Ribble Valley Borough Council
Council Offices
Church Walk,
Clitheroe
Lancashire
BB7 2RA

Phone: 0300 123 6780
Email: developeras@lancashire.gov.uk
Your ref: 3/2025/0536
Our ref: 3/2025/0536/HDC/KW
Date: 19 September 2025

Location: Dale Hey Bungalow Preston Road Ribchester PR3 3XL
Proposal: Part retrospective outline planning permission to demolish the existing bungalow and proposed new detached self-build 4/5 bedroom house with access applied for (all other matters reserved).
Grid Ref: 364085 436062

Dwng No. **A4578-PL03** Rev. **B**

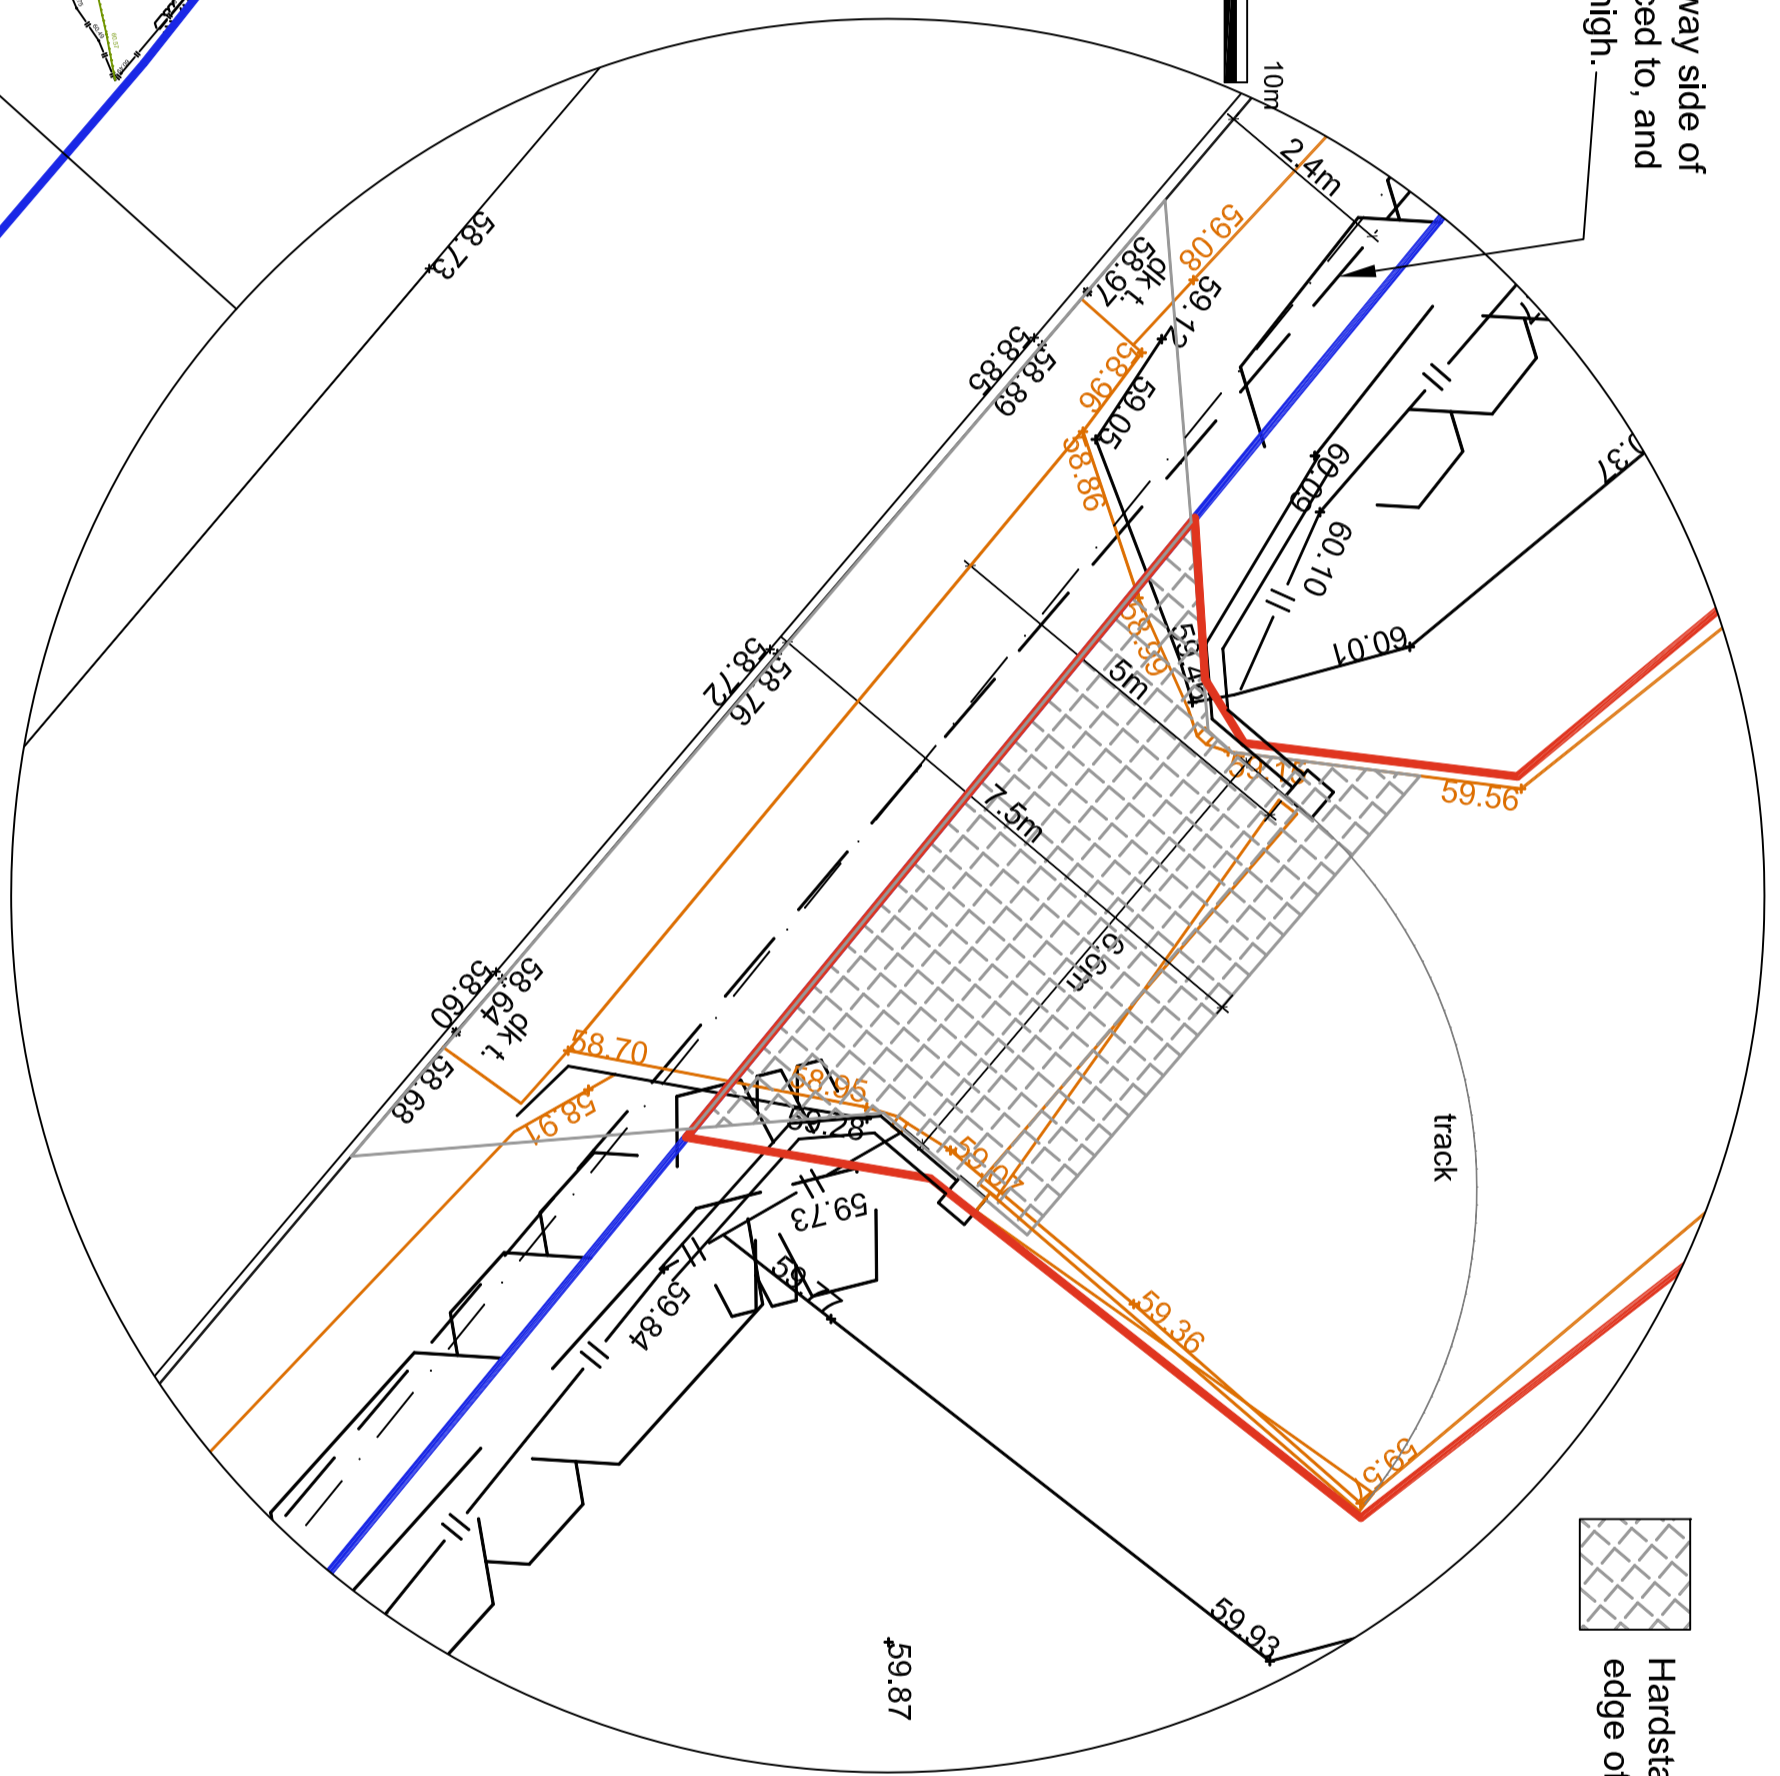
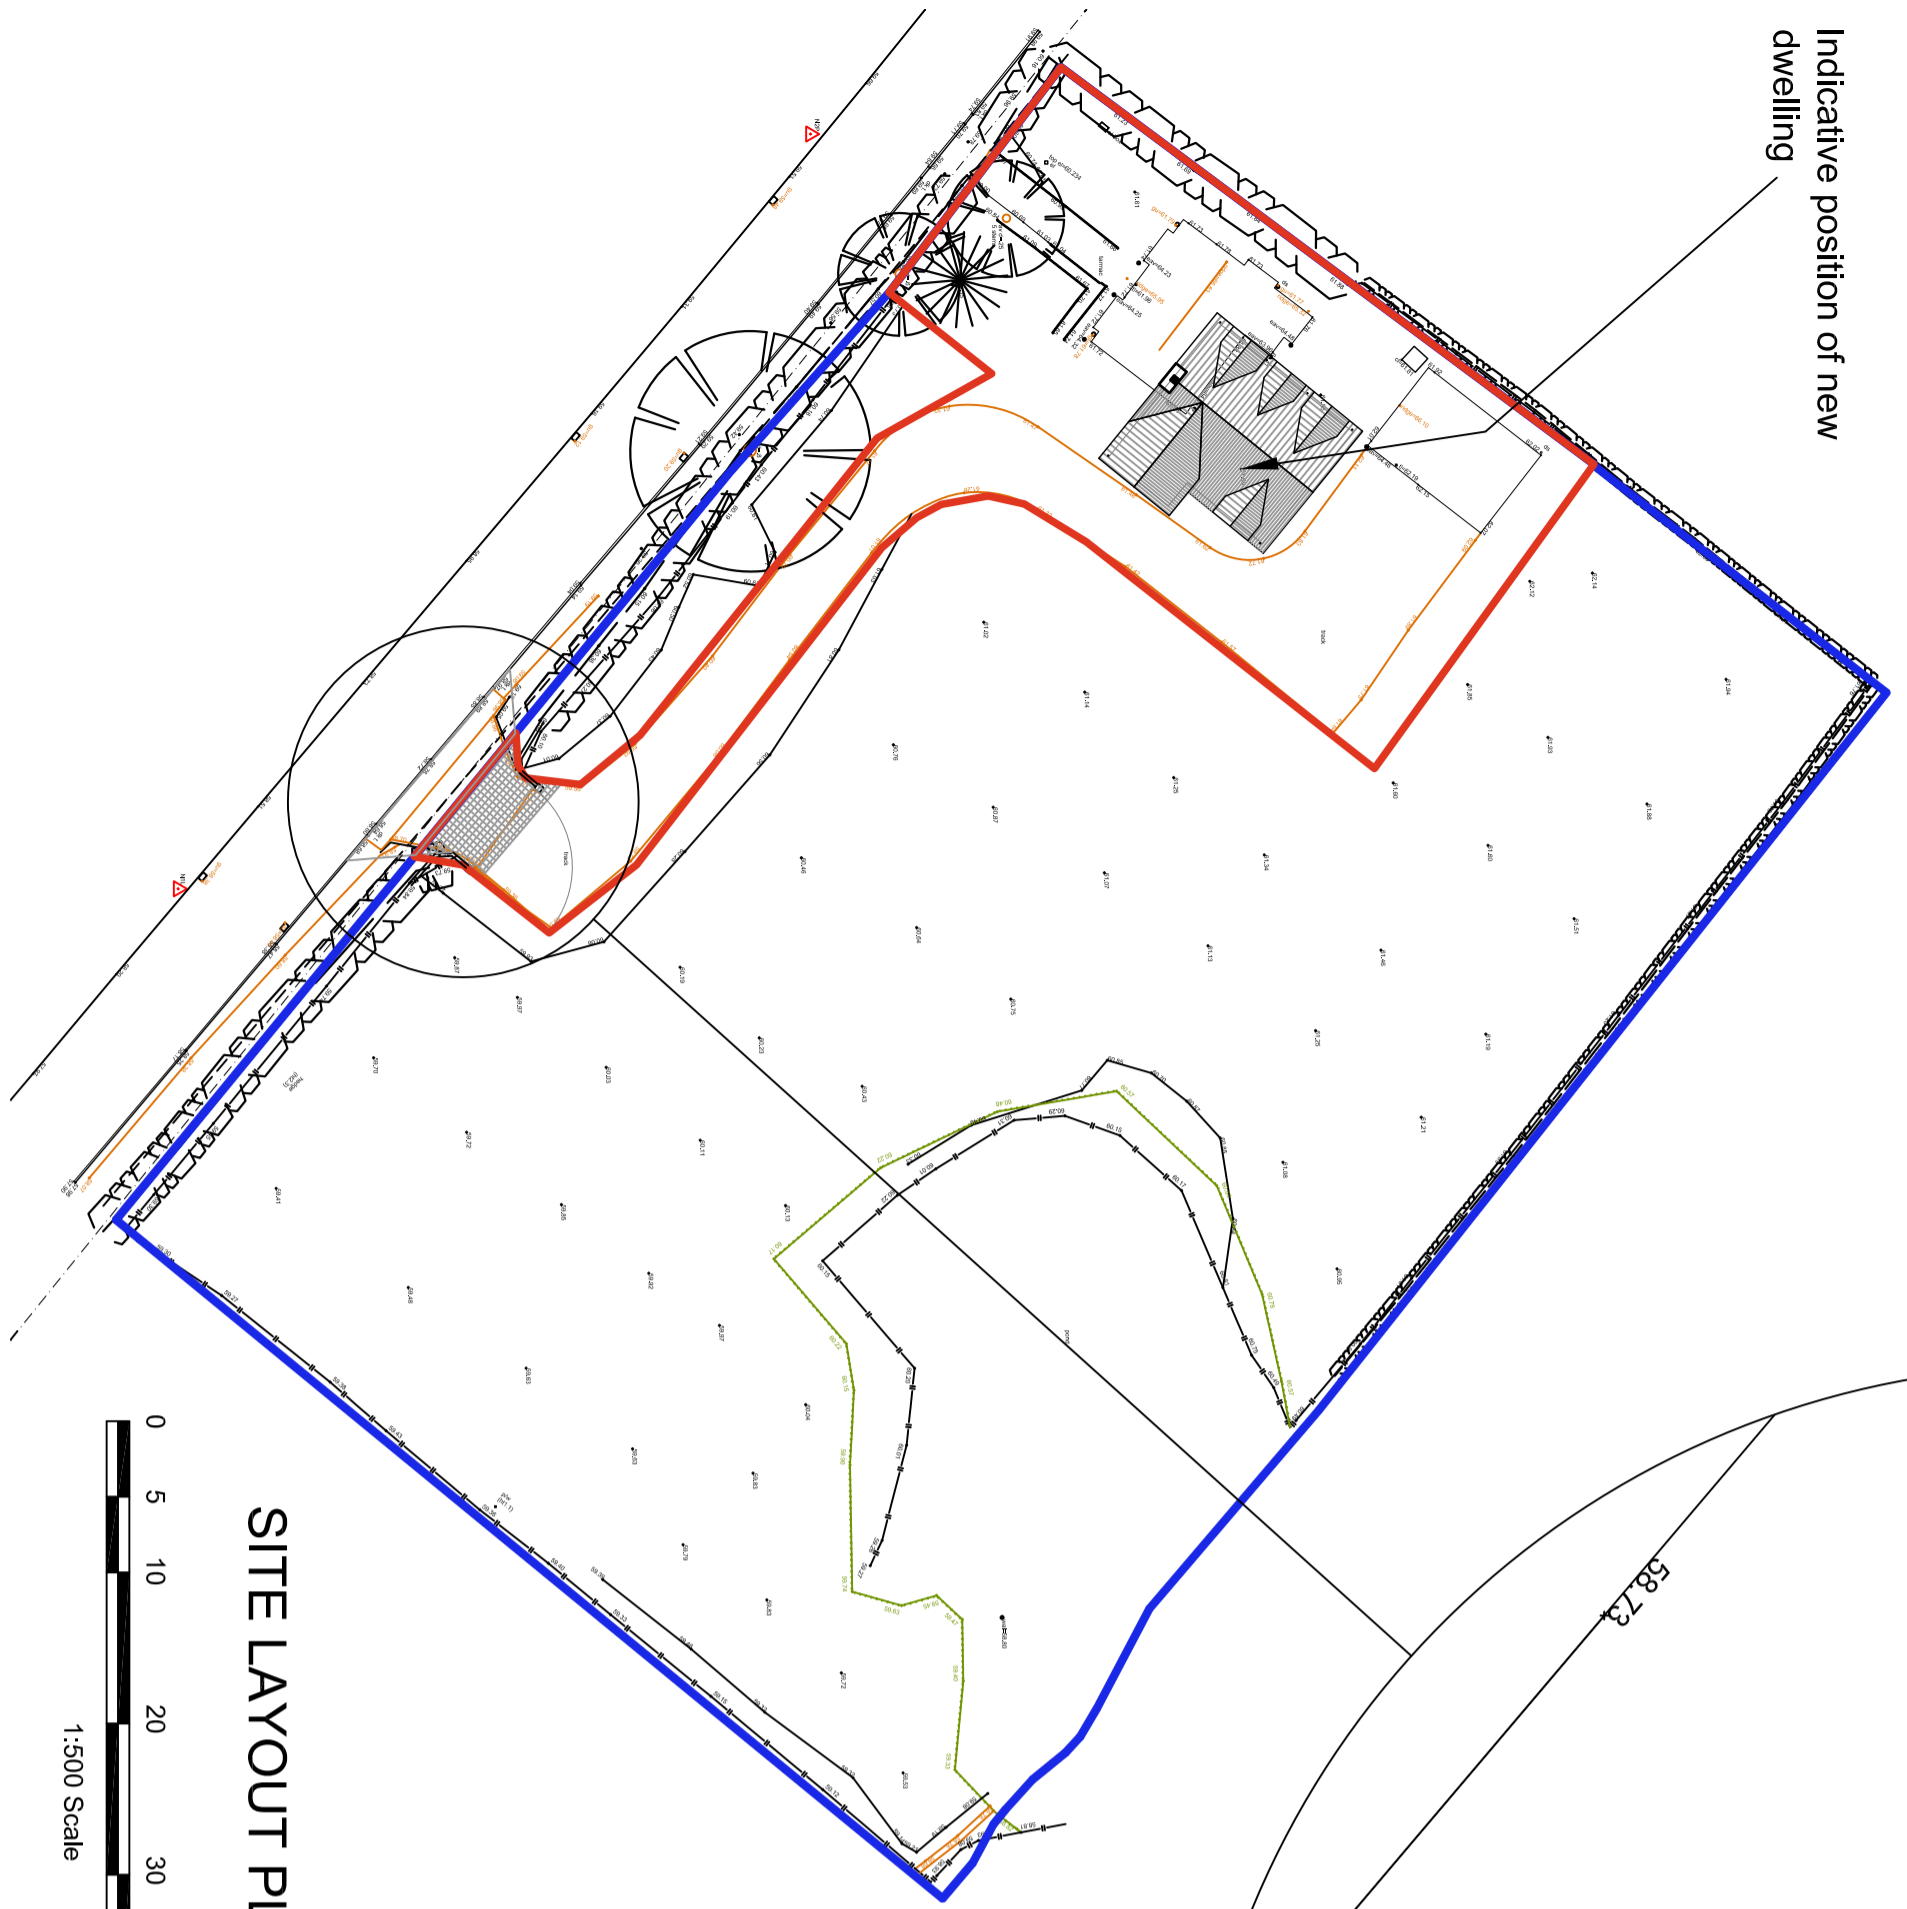
An access layout has been provided as part of this application with the relocation of the access on Preston Road. A new stone wall surrounding the access and gates to the vehicular access is also proposed. All structures and vegetation that fall within the visibility splay, which was approved as part of 3/2017/0813 shall be retained at no higher than 1m.

The LHA has reviewed the Proposed New Access drawing A4578-PL03 Revision C, which shows hard standing for 5m into the site from the highway boundary. The proposed gates are also situated 5m behind the highway, maintained at public expense, which allows vehicles to fully clear the highway before operating the gate, allowing for a safe and suitable access.

1. Before the access is used for vehicular purposes, that part of the access extending from the highway boundary for a minimum distance of 5m into the site shall be appropriately paved in tarmacadam, concrete, block pavements, or other approved materials. Reason: To prevent loose surface material from being carried on to the public highway thus causing a potential source of danger to other road users.

2. Before the development hereby permitted becomes operative, the existing hedge and vegetation on the highway frontage of the site to B6245 Preston Road, Ribchester shall be reduced to and be permanently maintained henceforth at a height not greater than 1m above the crown level of the carriageway of B6245 Preston Road, Ribchester.
Reason: To ensure adequate visibility for the drivers of vehicles entering and leaving the site.

3. Before the access is used for vehicular purposes, any gateposts erected at the access shall be positioned 5m behind the nearside edge of the footway/carriageway and visibility splay fences or walls shall be erected from the gateposts to the existing highway boundary, such splays shall be 45° to the centre line of the access. The gates shall open away from the highway.
Reason: To permit vehicles to pull clear of the carriageway when entering the site and to assist visibility.
